From: [Planning Department](#)  
To: [Steve Howes](#)  
Subject: PV Invoiced Planning Application Ref. PF/22/1243  
Date: 18 May 2022 12:56:49  
Attachments: [Specification 2022.05.04 at 11.31.06 am](#)  
[LG20\\_0000000000](#)  
21 Pages 4.9M

Subject: Re: Invoiced Planning Application Ref. PF/22/1243

WEST ELEVATION
Scale 1:100

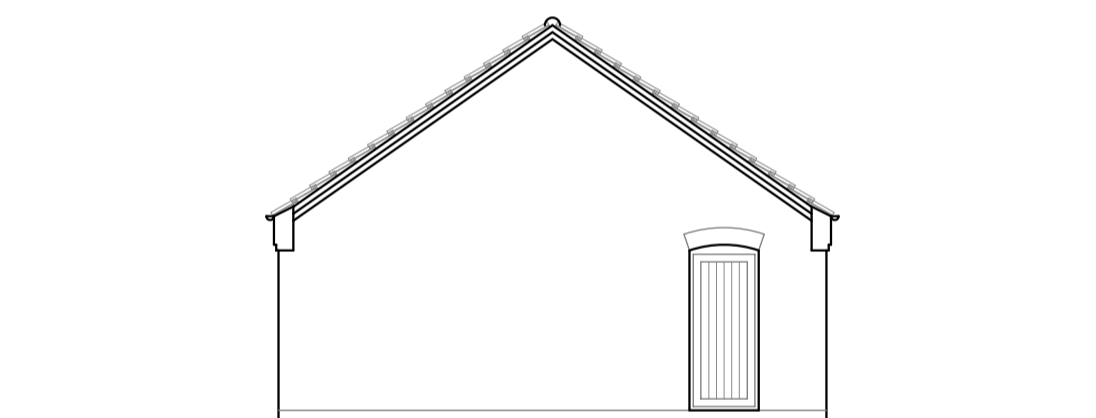
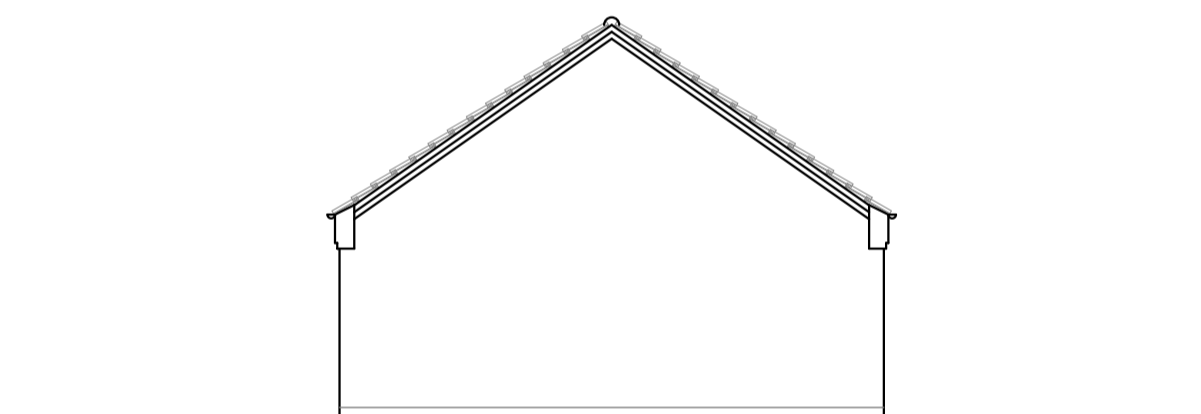
See attached the garage door removed from the West Elevation (the plan is correct).
